DFT PR-2024-010446

SI-2024-00774

RESPONSE TO: Code Enforcement Comments

Drawing file: 2-24-2025 / -AC3 PAVING PLAN.pdf

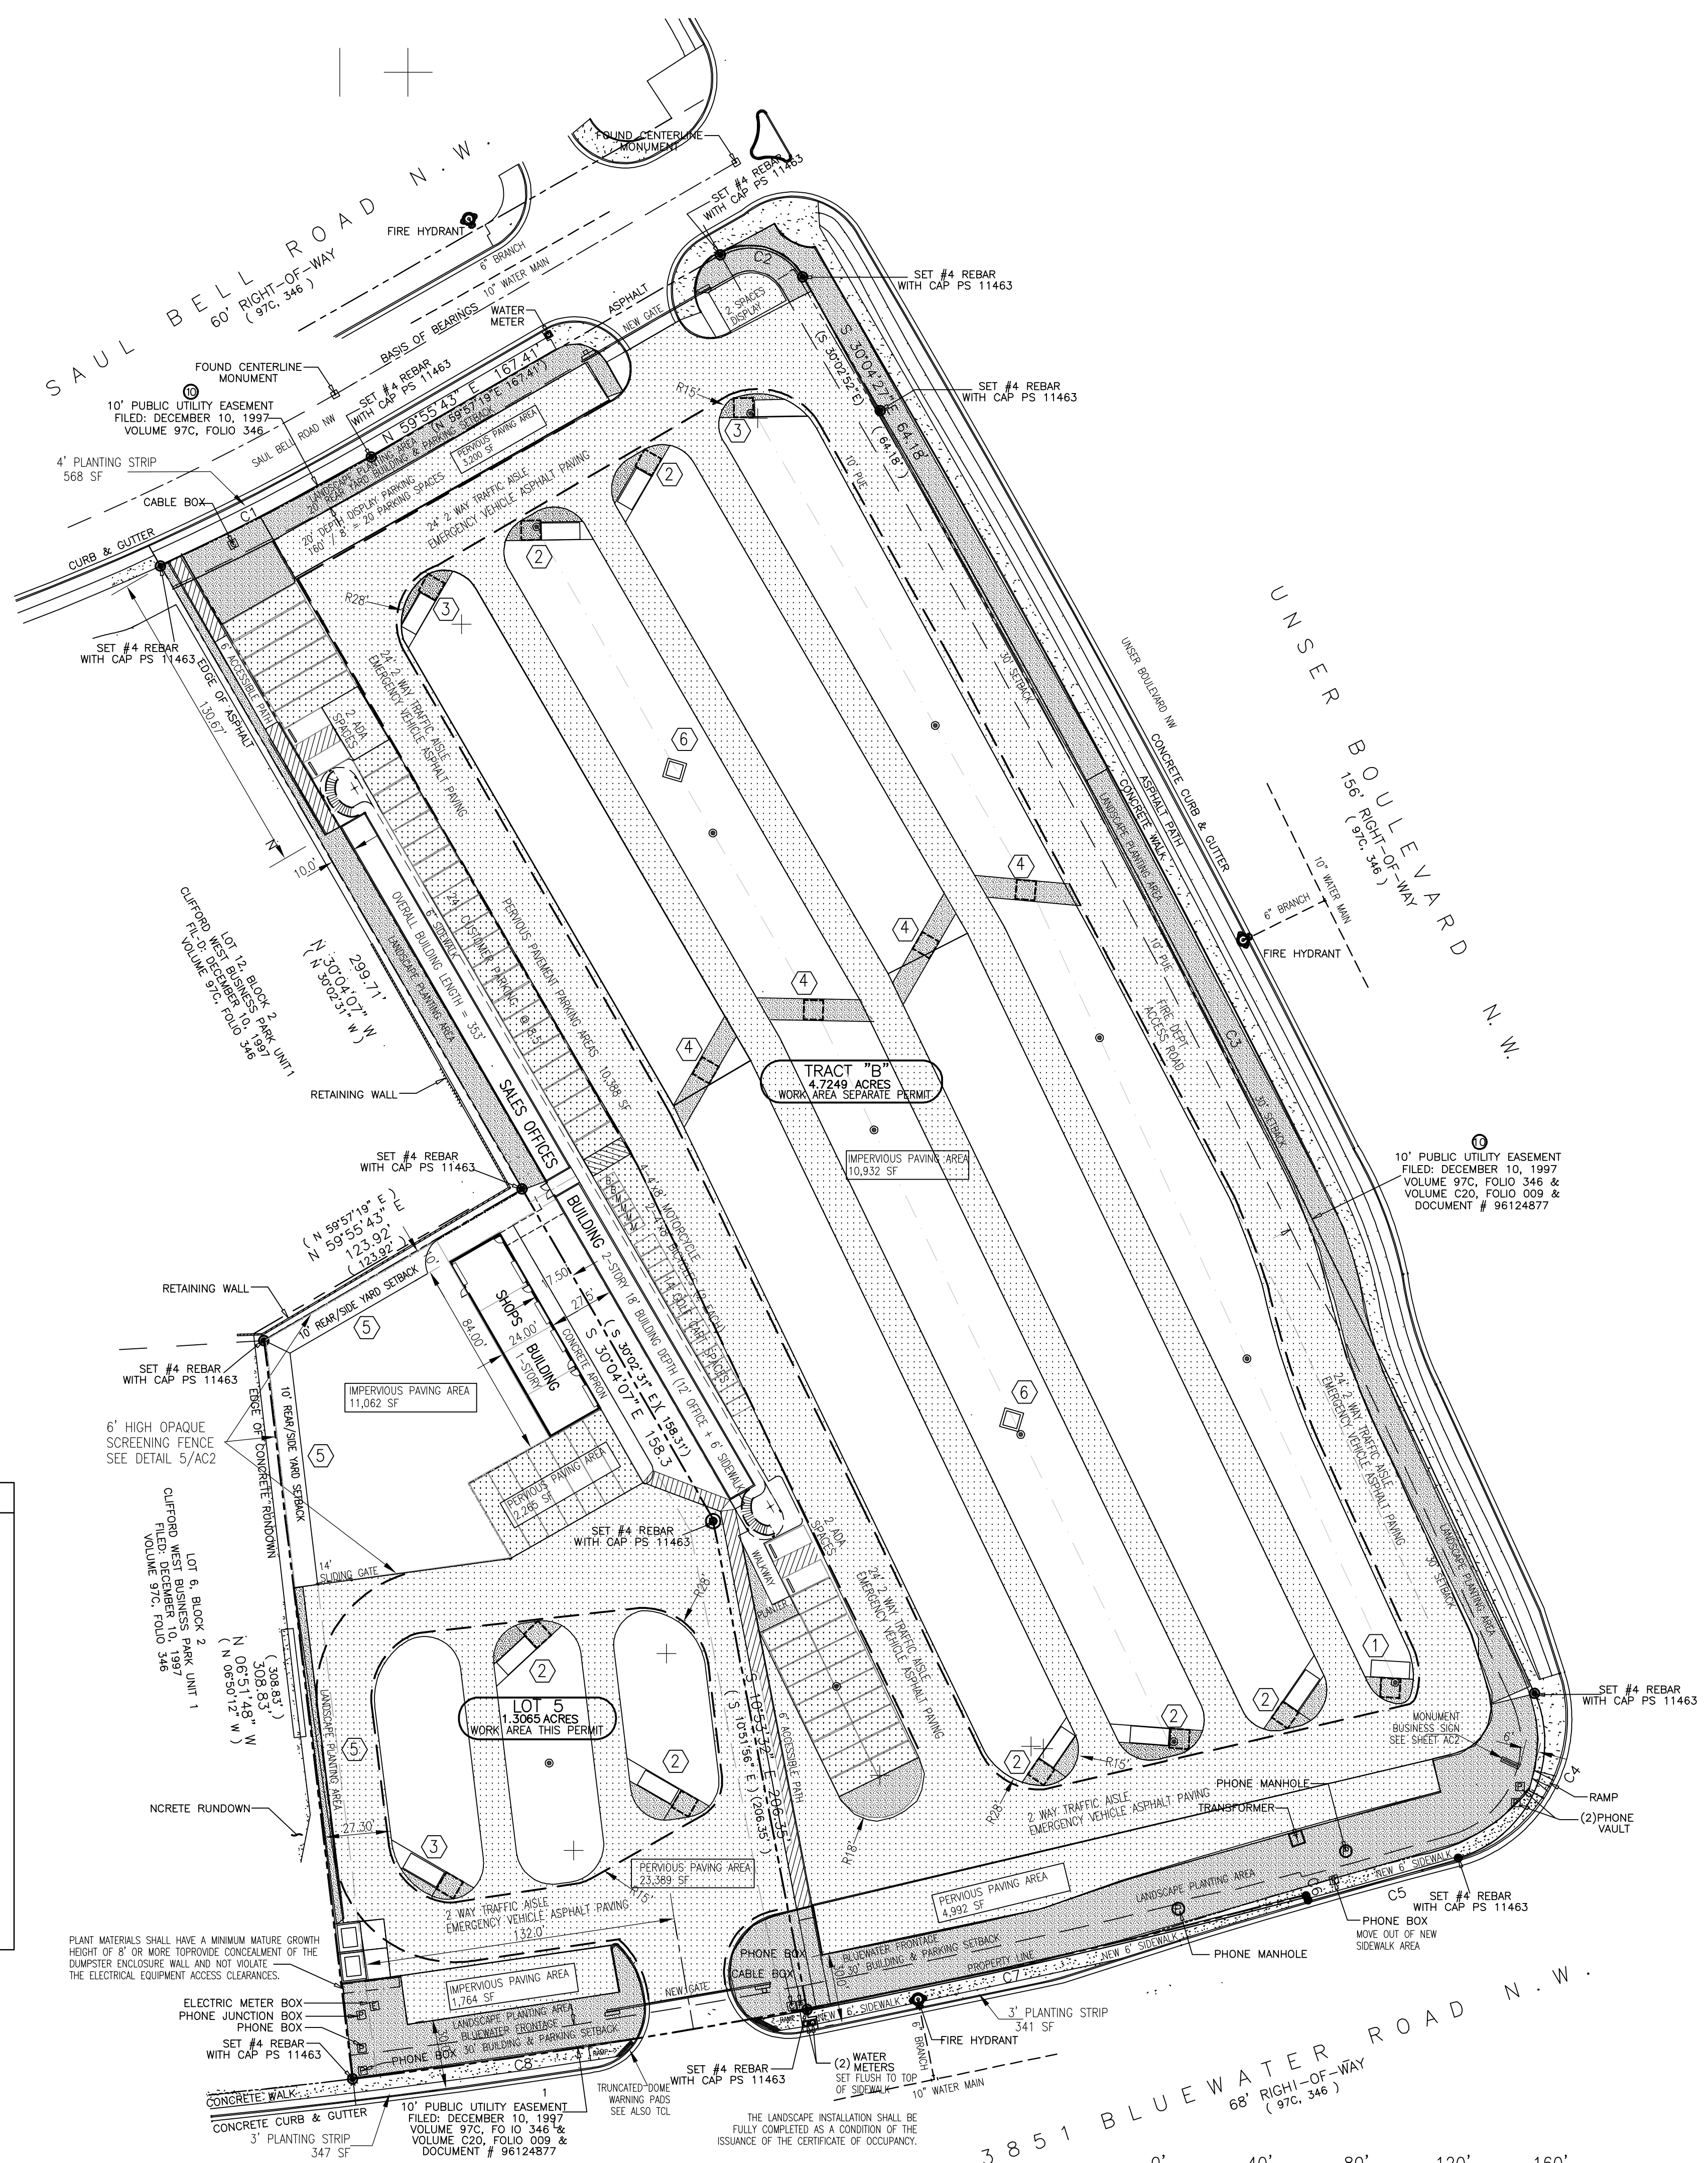
1. --Please identify other areas on the lot where landscaping can be added to fulfill this requirement. Please note that regulations below on dimensions of tree planter areas and confirm compliance.

1. The minimum size of tree planters within off-street parking areas shall be 60 square feet per tree. This requirement may be reduced to 36 square feet if the surface of a parking or vehicle circulation area abutting the tree planter is of a permeable material and, combined with the tree planter area, meets the 60 square foot per tree requirement.

RESPONSE: See attached new drawing Paving Plan Sheet AC3 for details to document the size and locations of spot planters shown in the previous submittals. The area of planters exceeds the 60 square feet per tree minimum requirement.

Drawing file: 2-24-2025 / A1-OFFICE PLANS & ELEVS.pdf

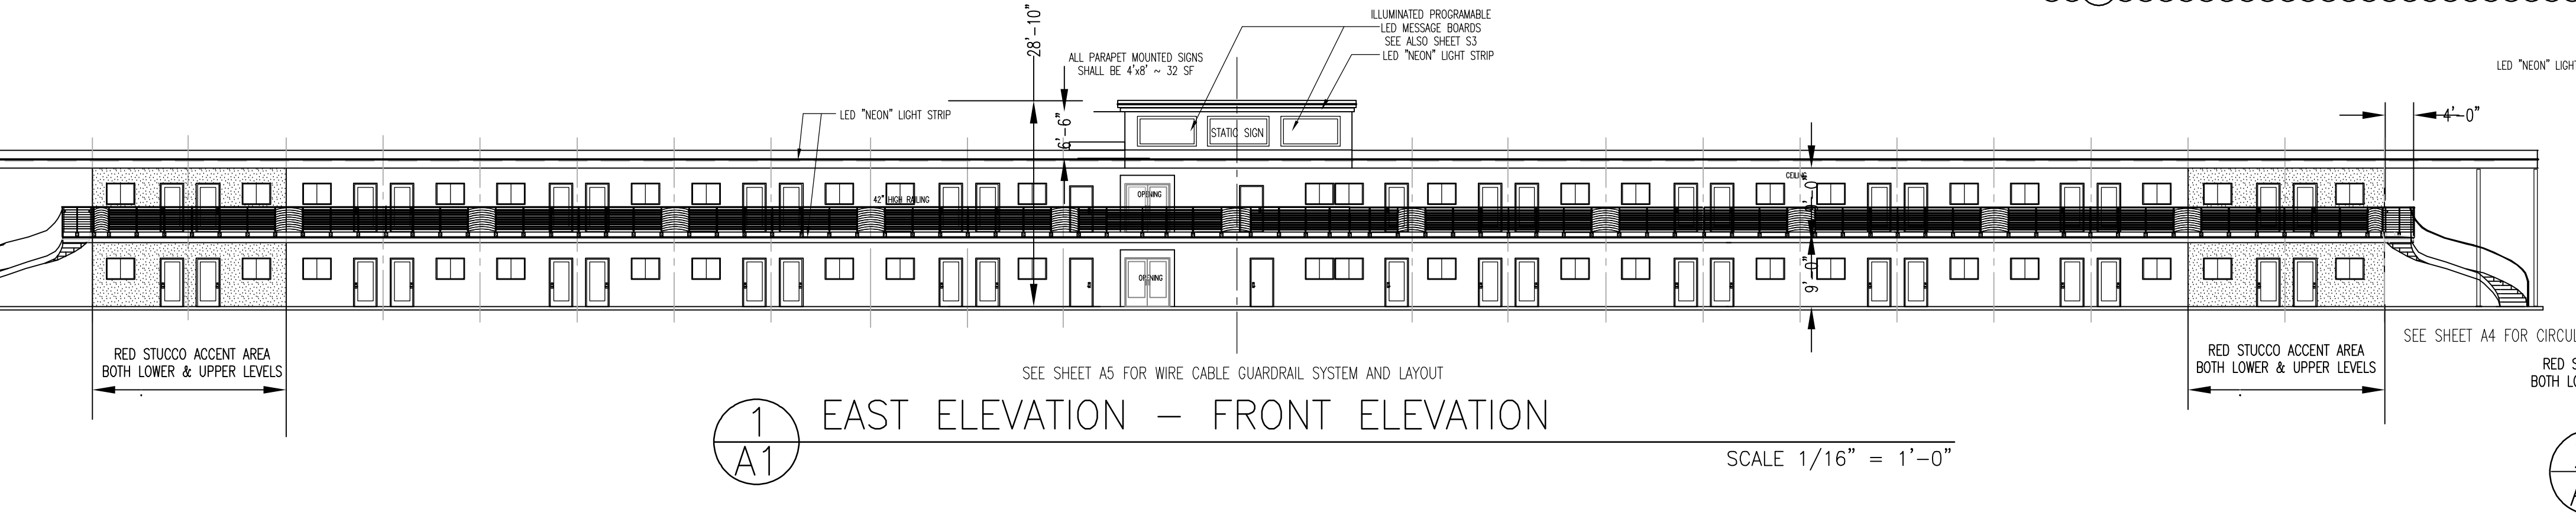
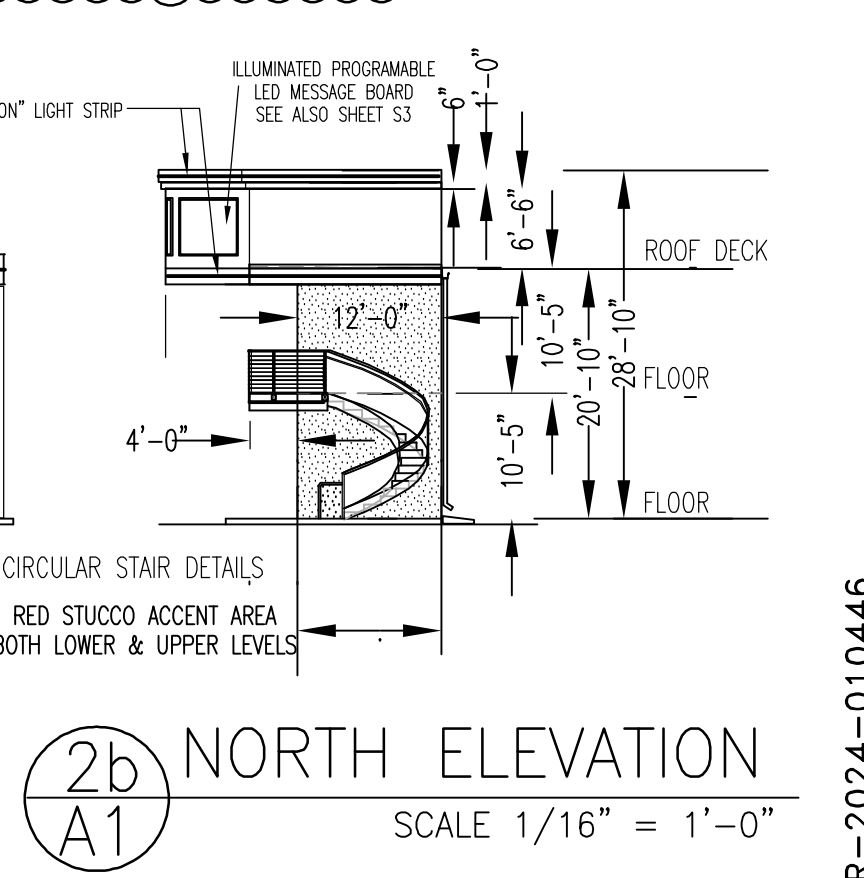
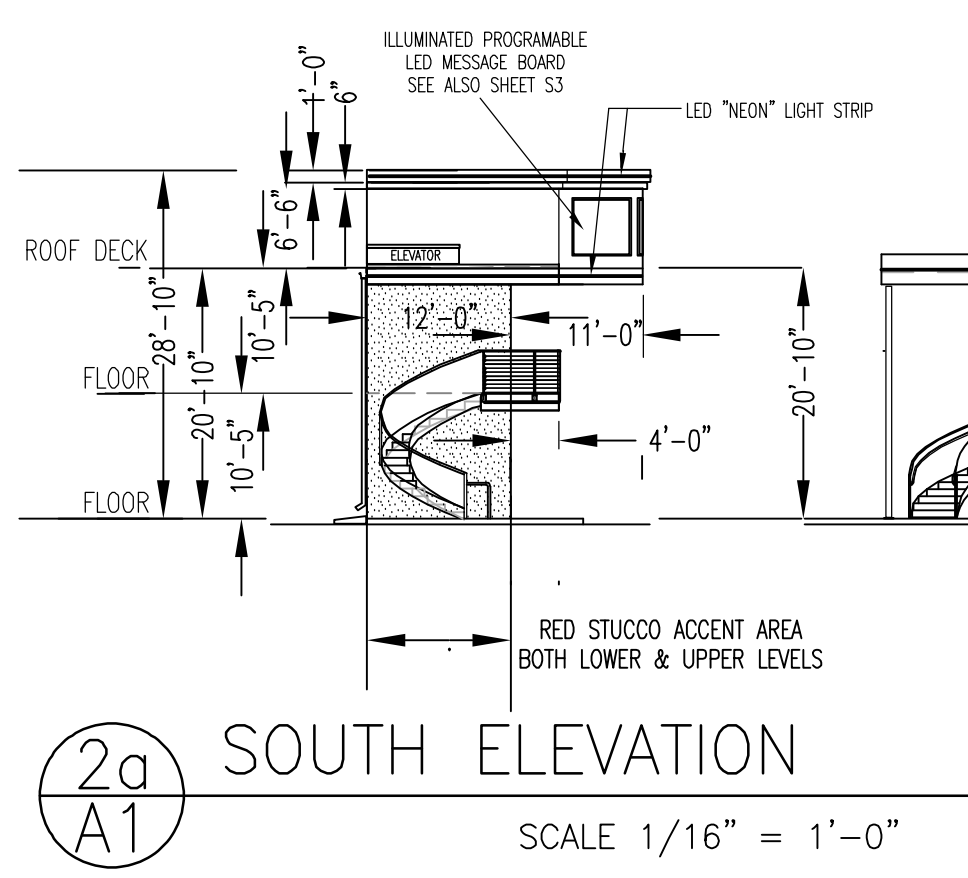
- **Elevation pages need to include measurements, dimensions, and information regarding screening. Provide detail to demonstrate and explain compliance with all sections within 5-11-E and 5-11-E-2.**

Include detail regarding how the façade and colors will meet the Clifford plan design requirements.

See drawing A1 for the business signs that are to be mounted on the roof equipment screening parapet. The Office Building Parapet screen wall will be surface mounted painted inserts with face lighting fixtures. No electronic signs will be installed. All exterior fixtures are dark-sky rated.

The CWMP Section **BUILDING REGULATIONS** details various means and measures to be employed in the façade design of buildings. These definitions and the IDO requirements are similar enough that one reflects the other. Both the CWMP and the IDO concerns are addressed as described below. The Building Elevations are shown on Sheet A1 Office Building and Sheet A6 Shops Secondary Building.

provide a sophisticated Business Park for Albuquerque’s southwest area. See new Sheets A1 and A6 for elevation information. Concept designs also enclosed for visual clarification.
